West Circular Quay Public Domain Upgrade Works - Major Project 10_0104

Applicant Response to Submissions

PRINCIPLES

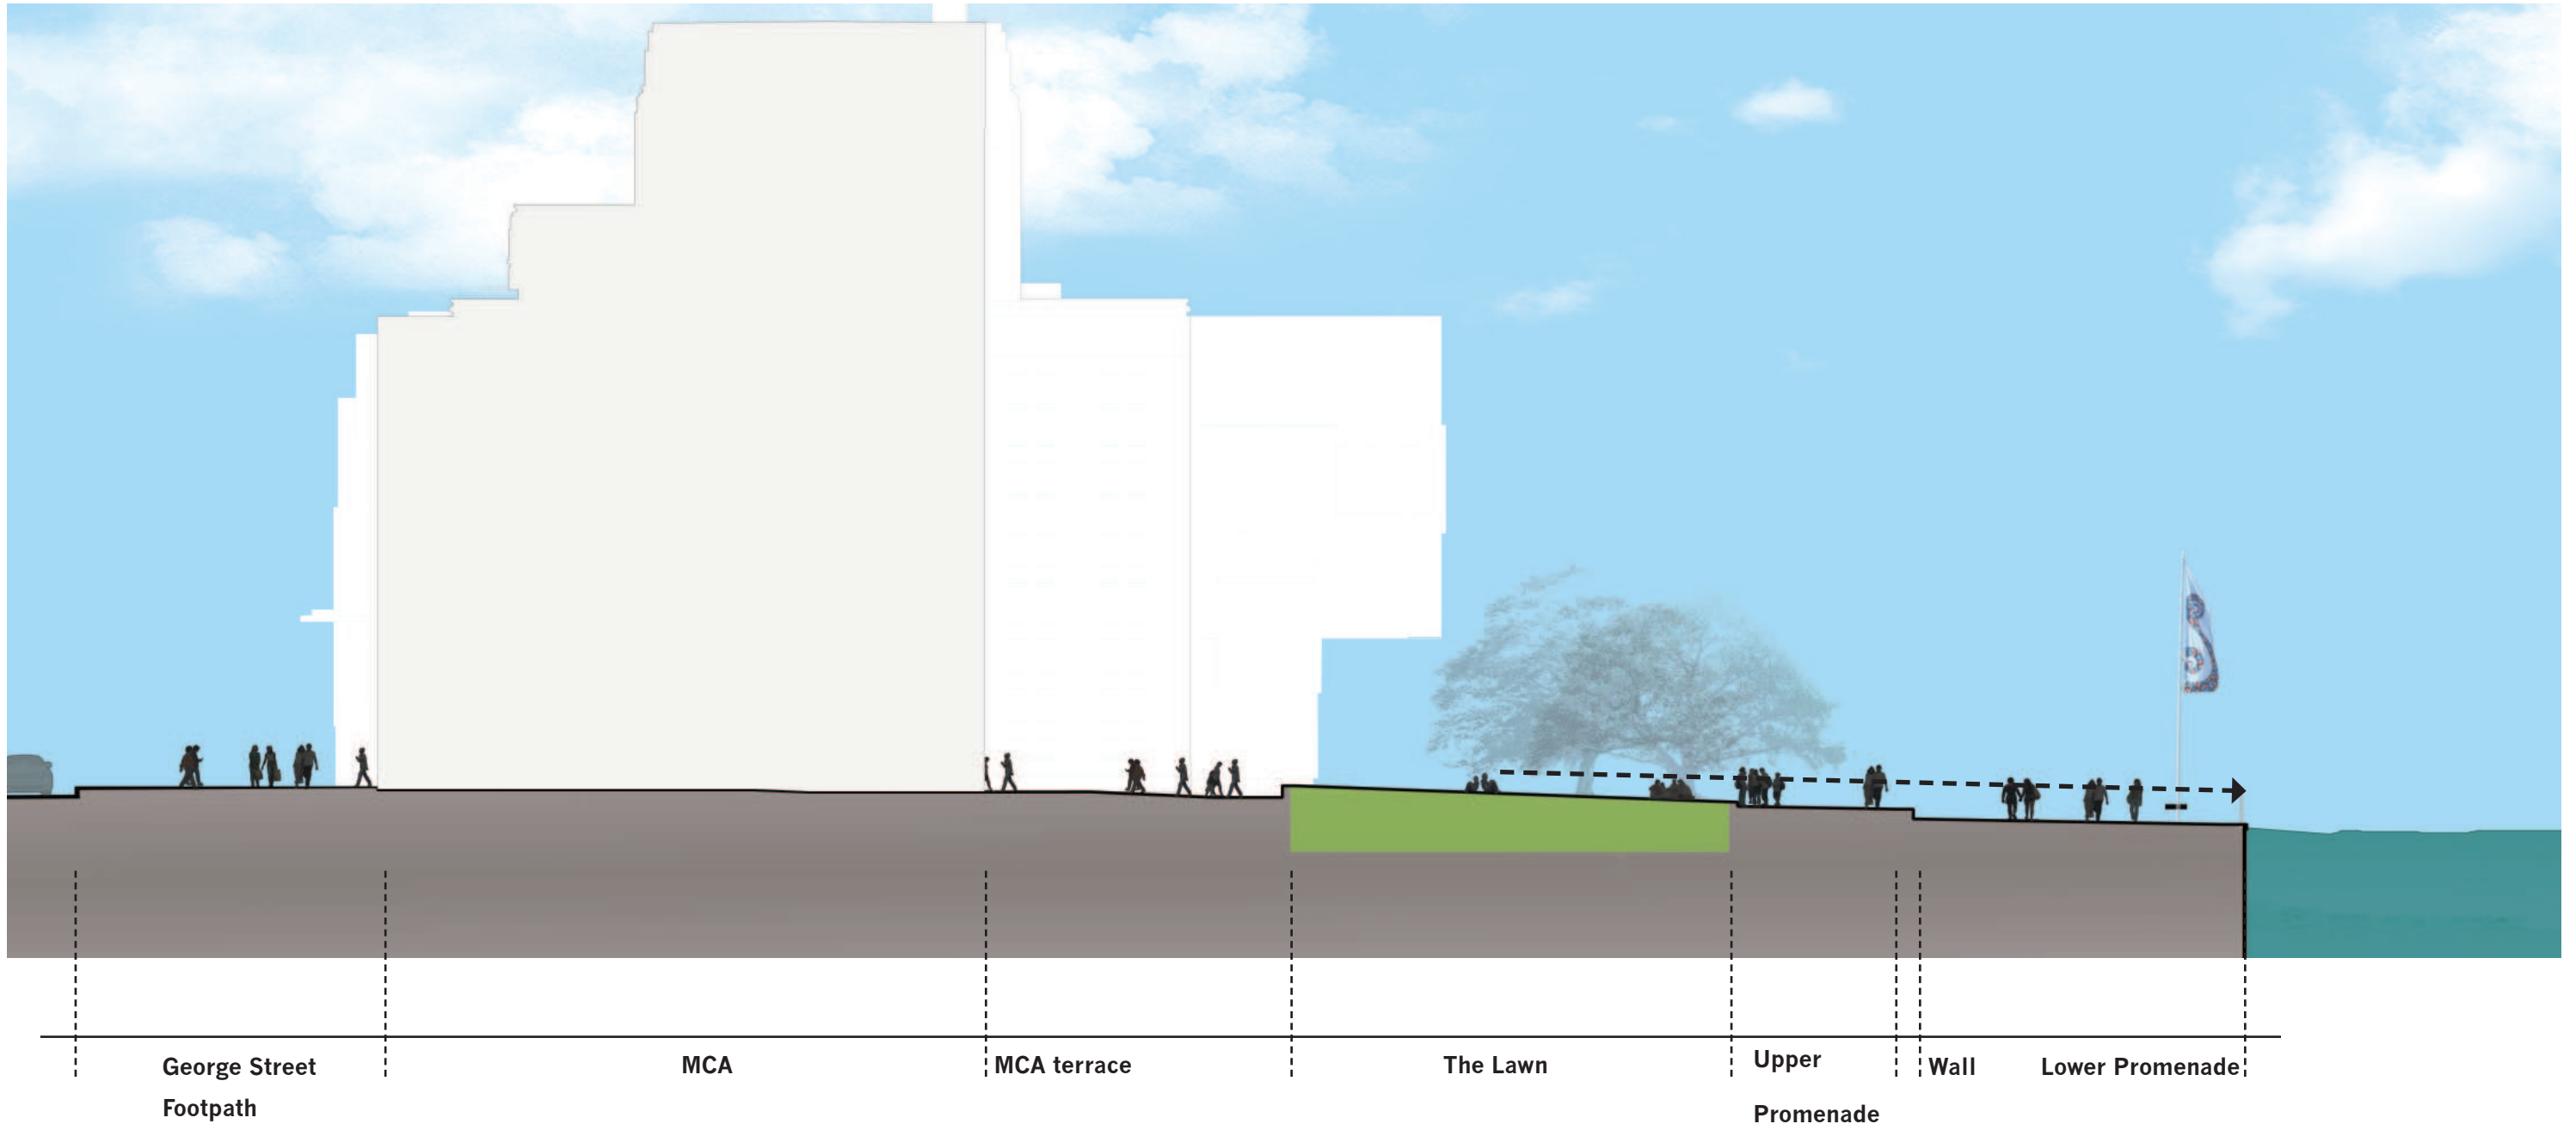
4. Lighting:	
a. The "sphere" type pole-mounted lighting design was not supported by Jørn Utzon for use around the Opera House and should not be continued.	The Project lighting is based on a consistent upgrade of existing foreshore luminaires (from <i>Macquarie</i> to <i>Bennelong</i> lights) along the foreshore south of Argyle Street/OPT.

b. The cost of the entire lighting scheme is potentially grossly underestimated and/or inadequate and should be re-evaluated.	The lighting cost refers to the replacement of the luminaires to the compliant <i>Bennelong</i> type fittings only. The Project does not include the relocation of light poles.

c. Insufficient details are provided about the type of light fitting in "Market Wharf".	Details are provided under Project Plan 7. <i>Lighting</i> and to EA report section 3.2 sub-section 8. <i>Provide lighting that fulfils the requirements of safety whilst allow for opportunities to enjoy the nighttime experience of key Harbour landmarks.</i>

Cahill expressway

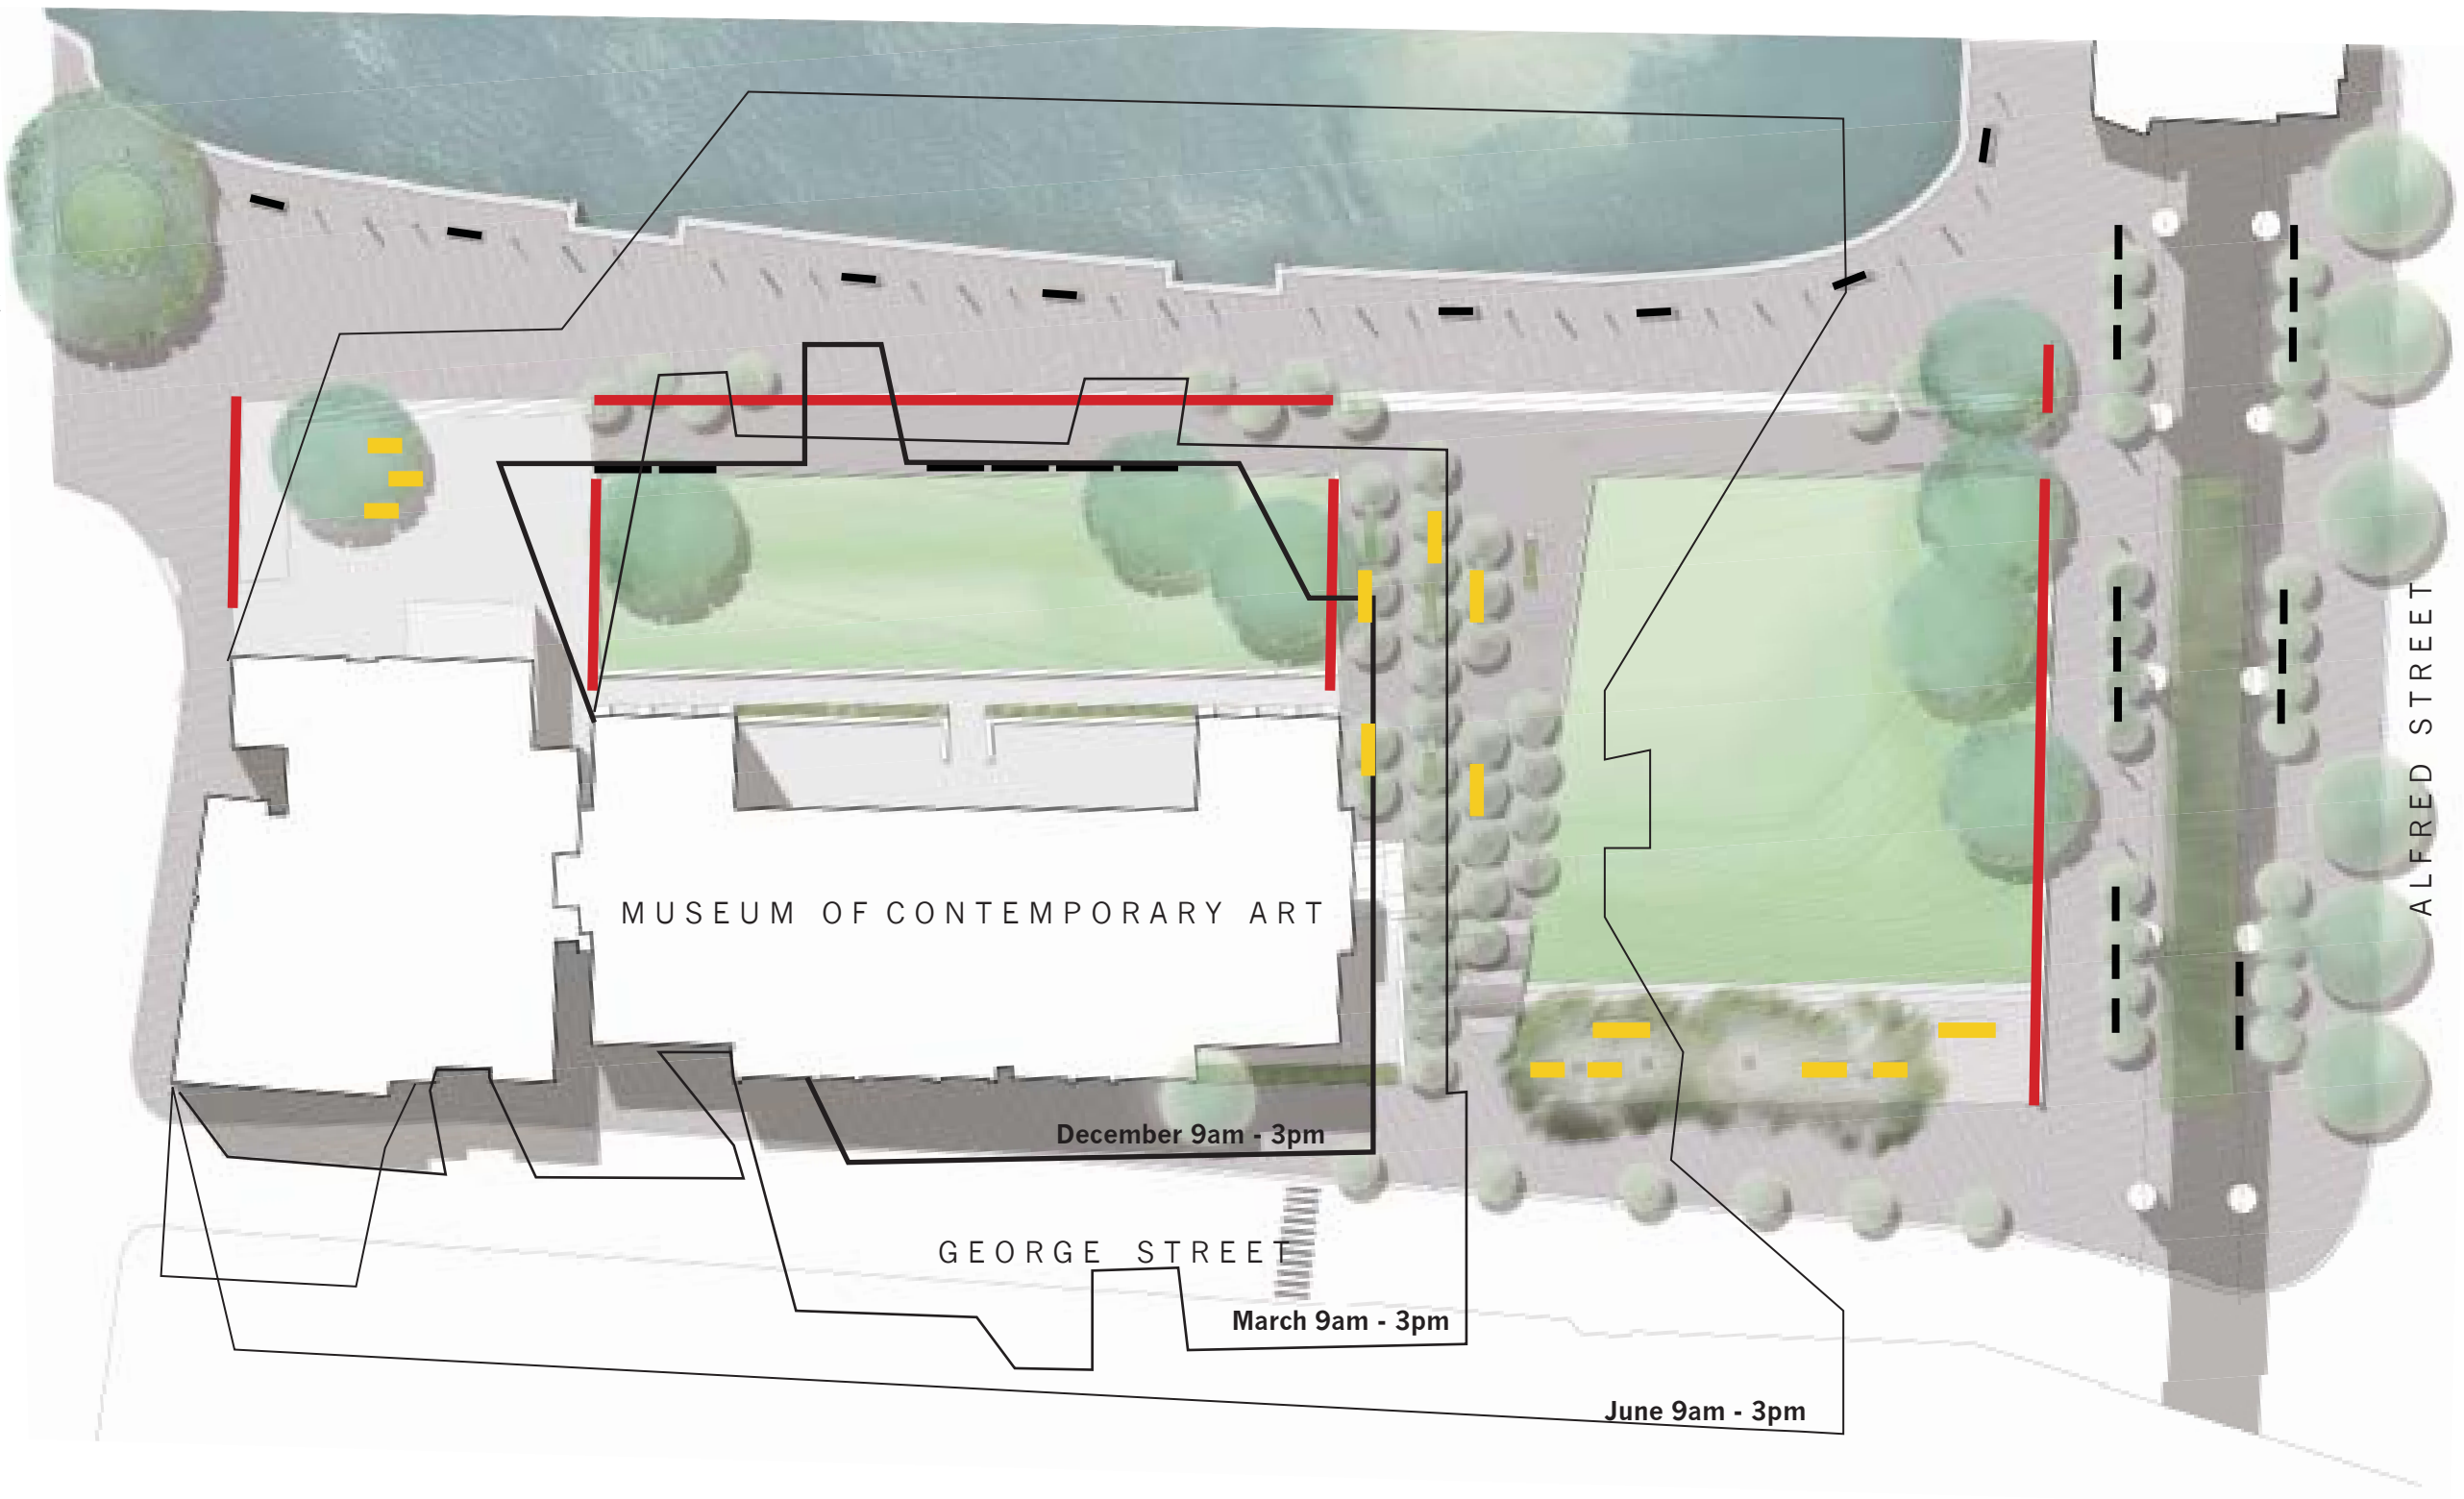
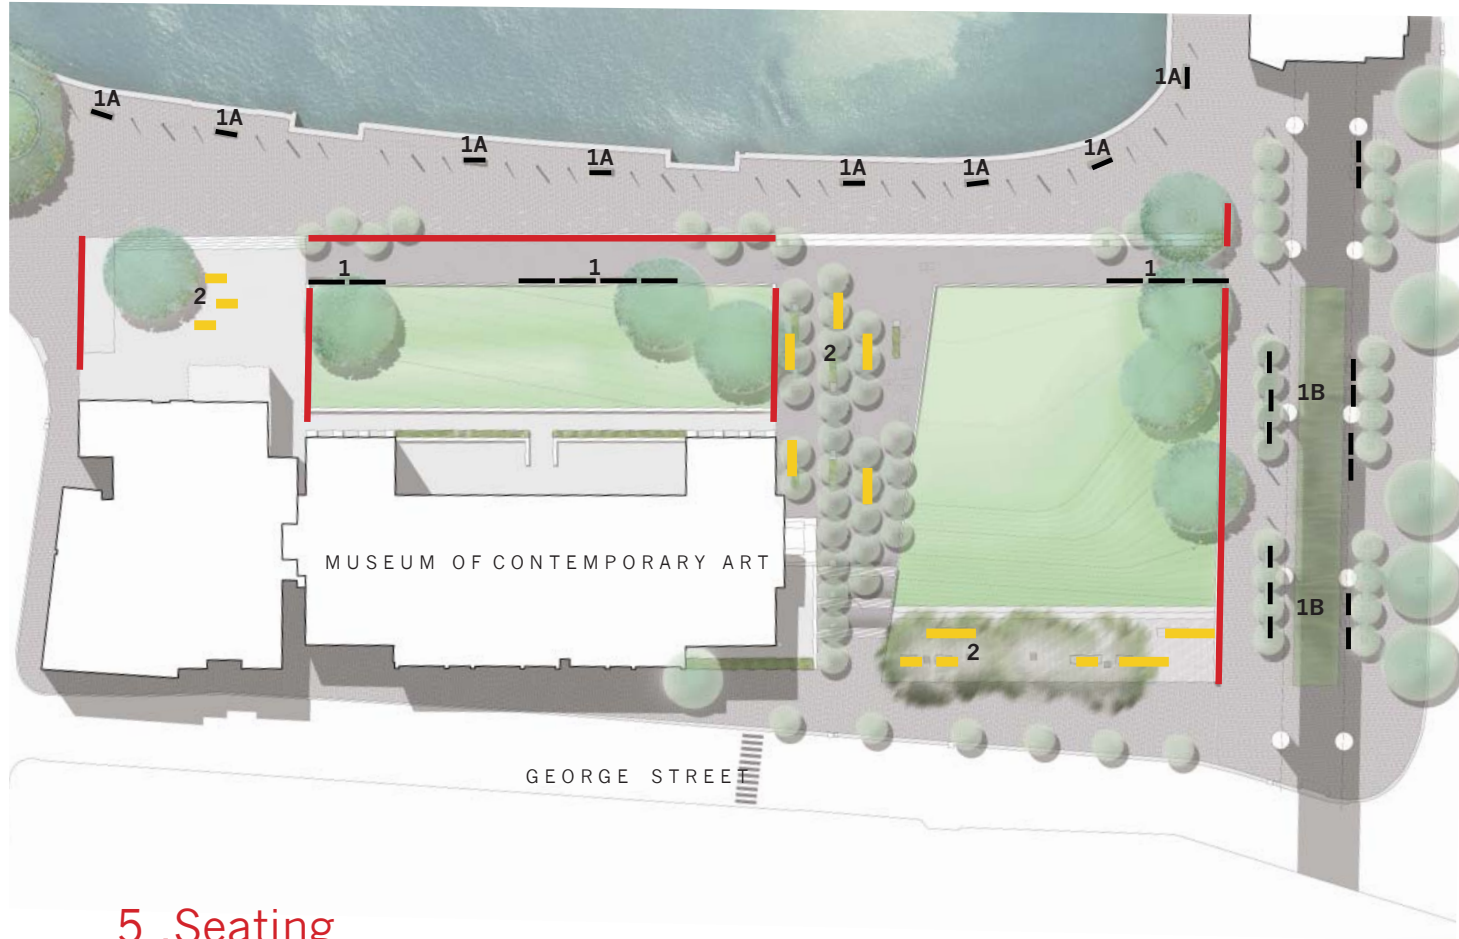
2. Alfred Street & George Street frontages: a. Insufficient details are provided about the existing and proposed features along the George and Alfred Street frontages, including paving, street furniture and the "Green Roof Walk". Given that this is the primary interface between West Circular Quay and the City, a high level of resolution and design documentation is required to show alignment levels, footpath grades and surface drainage at these frontages.	Details are provided in the following Project plans: 1. Shade & Trees; 2. Seating; 3. Paving; 4. Lighting; 9. Interpretation; and also under EA report section 3, which describes the proposed works. The "Green Roof" component is deleted from the Project. Consequently, the Project is amended to increase the sense of green under the Cahill expressway. A generous planting bed has been included that deals with the level change. Low, colourful, shade-tolerant species will ameliorate the paved expanse while allowing clear sightlines through to the Quay. A stepped path is provided to maintain free flowing pedestrian access from both Pitt Street crossings. Palm trees have been relocated to the northern side of the expressway to allow optimum canopy spread to Alfred St street trees. A Project Planting Plan for the 'Cahill Expressway Undercroft' accompanies this letter.

1. The "Green Roof" component is **deleted** from the Project.
2. Consequently, the planting area to the Cahill Expressway undercroft is amended to increase the sense of green. A generous planting bed has been included that deals with the level change. Low, colourful, shade-tolerant species will ameliorate the paved expanse while allowing clear sightlines through to the Quay. A stepped path is provided to maintain free flowing pedestrian access from both Pitt Street crossings. Palm trees have been relocated to the northern side of the expressway to allow optimum canopy spread to Alfred Street trees.

A Project Planting Plan for the 'Cahill Expressway Undercroft' accompanies this letter.
